Application by Suffolk County Council for an Order Granting Development Consent for the Lake Lothing Third Crossing (Lowestoft)

Planning Inspectorate Reference TR010023

**Transport/Highways Supporting Evidence on behalf of Northumbrian Water
Limited**

Project Ref: 42498/001 | Date: January 2019

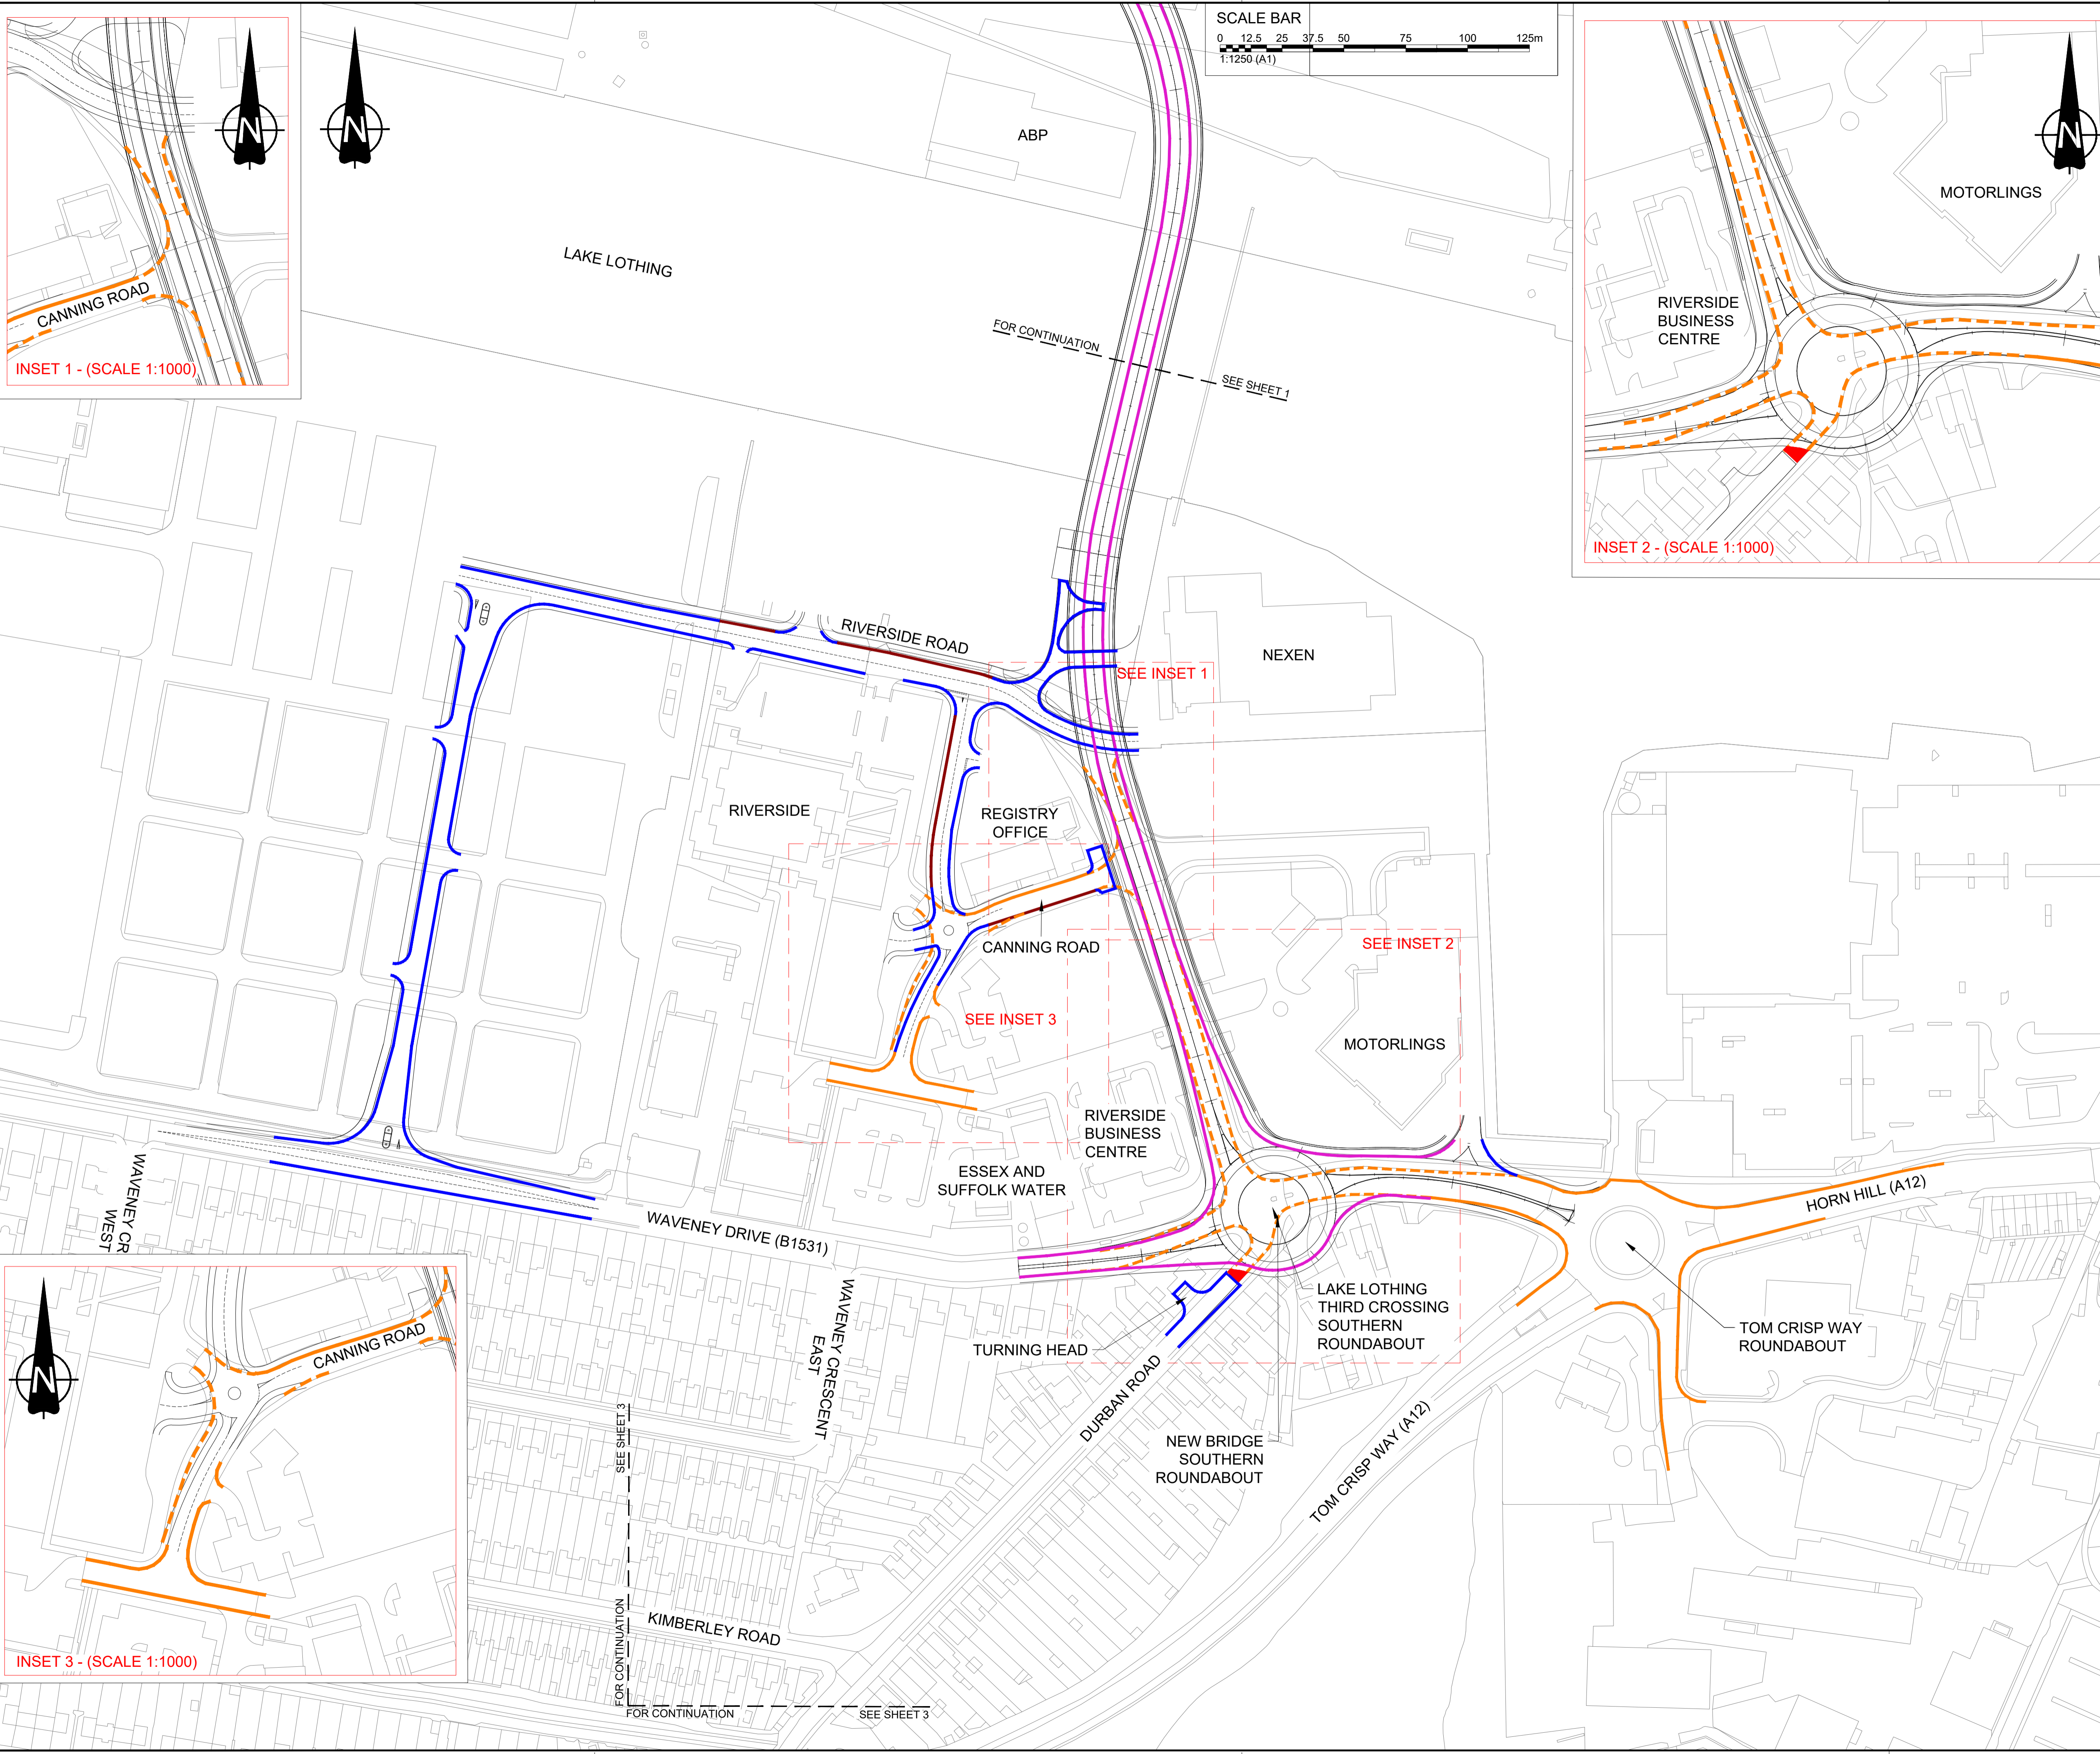
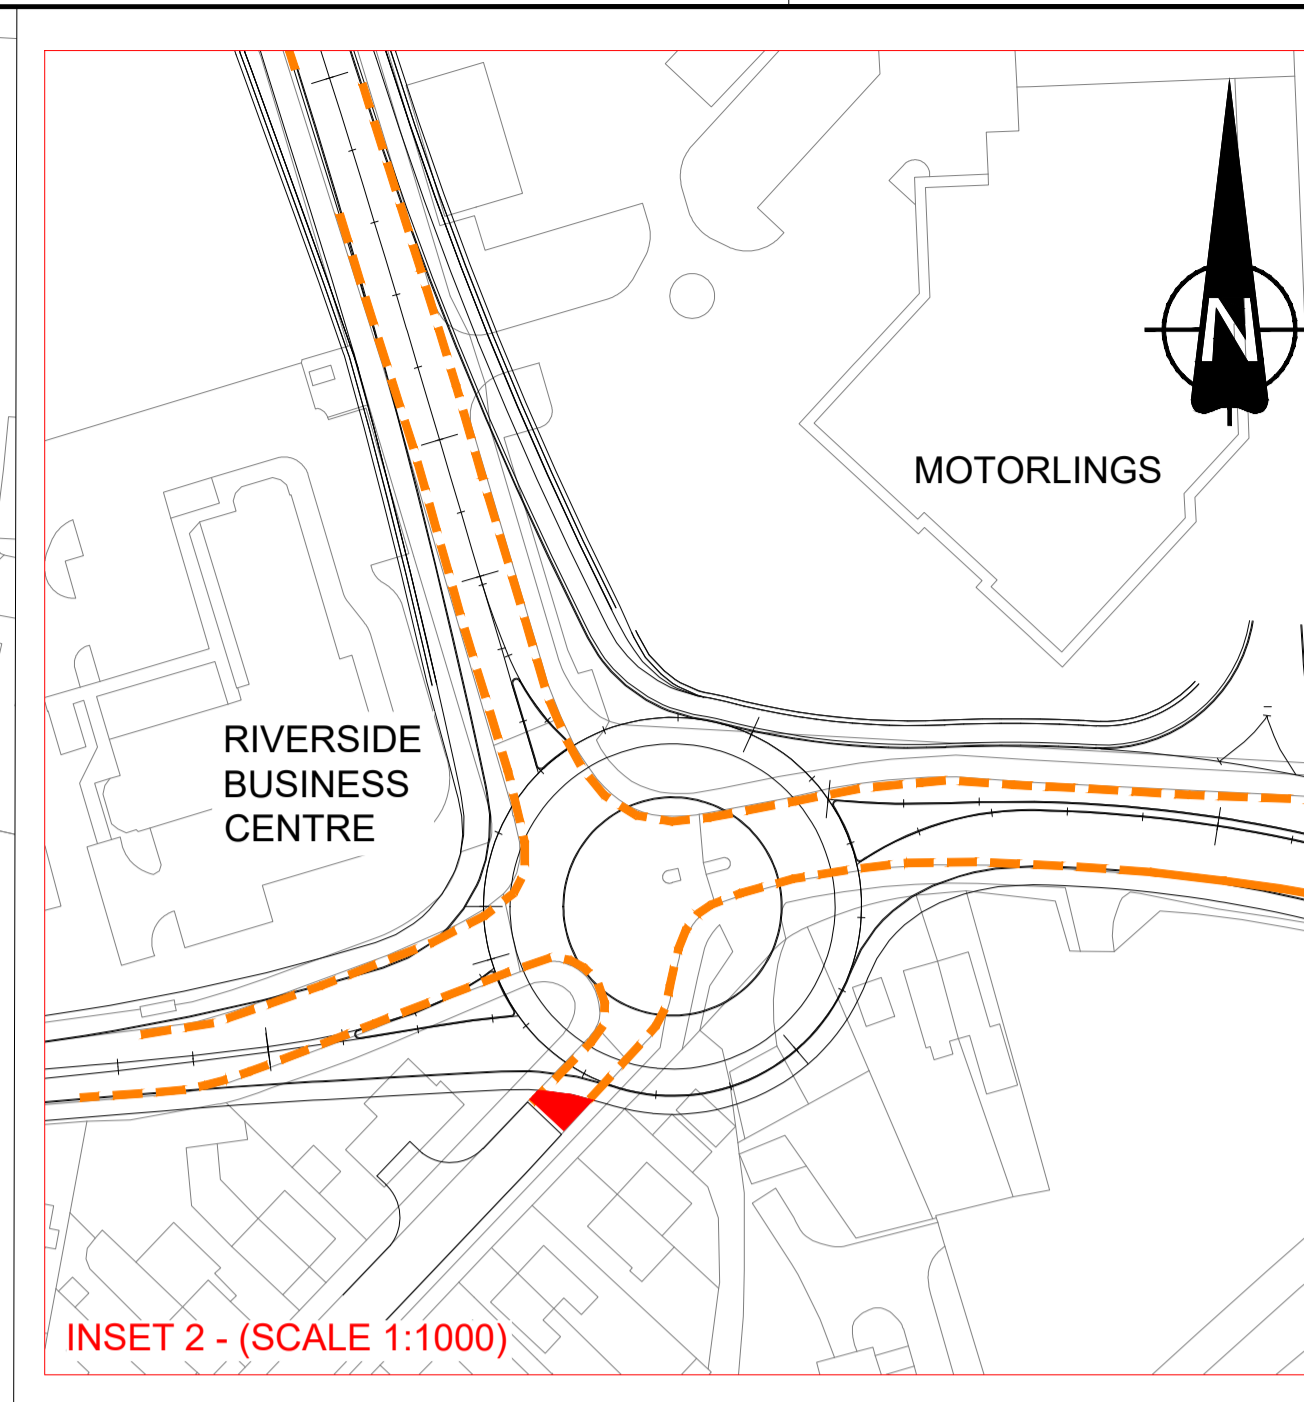
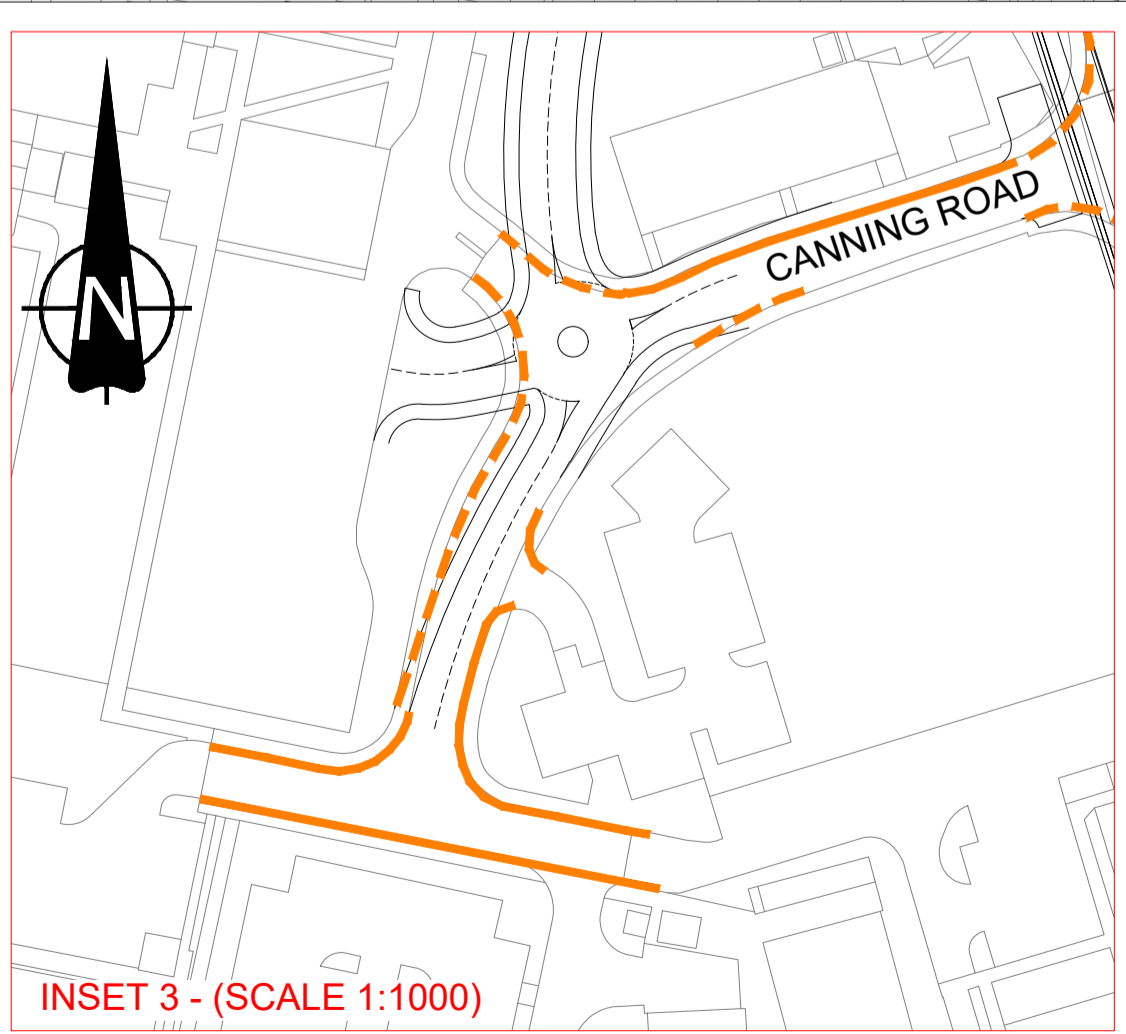
- 3.3.8 The proposed Scheme will have an adverse impact on on-street car parking arrangements at Riverside Business Park. Section 4.6 of the Transport Assessment June 2018 (Document Reference 7.2) details the proposed parking arrangements. Key aspects from this Transport Assessment are summarised below.

- 3.3.9 The implementation of the Scheme will result in the loss of around 290m (48 vehicles) of existing kerbside parking space along Riverside Road and Canning Road.

- 3.3.10 Further, the whole of Canning Road will be subject to parking restrictions, with no on-street parking available except for a short section of proposed parking opposite the Registrar's Office (highlighted in green on the Traffic Regulations Measure Plan – Figure 5 above). However, this short section of on-road parking will have a 2 hour parking limit. The Transport Assessment does not state how this will be enforced, particularly since Canning Road is currently unadopted. There is no formal proposal to adopt Canning Road in the draft Development Consent Order.

- 3.3.11 The Transport Assessment provides no specific reasons as to why Canning Road will be subject to parking restrictions along its entire length. Paragraph 4.6.2 simply states that *“improved connectivity for pedestrians and cyclists as a result of the Scheme will encourage a shift away from private cars to more sustainable modes of transport. The existing levels of car parking demand along Riverside Road are therefore expected to reduce as a result of the Scheme”*.

- 3.3.13 This amendment to the existing on-street car parking regime will have a direct impact on the Trinity House operation, and no mitigation is proposed.
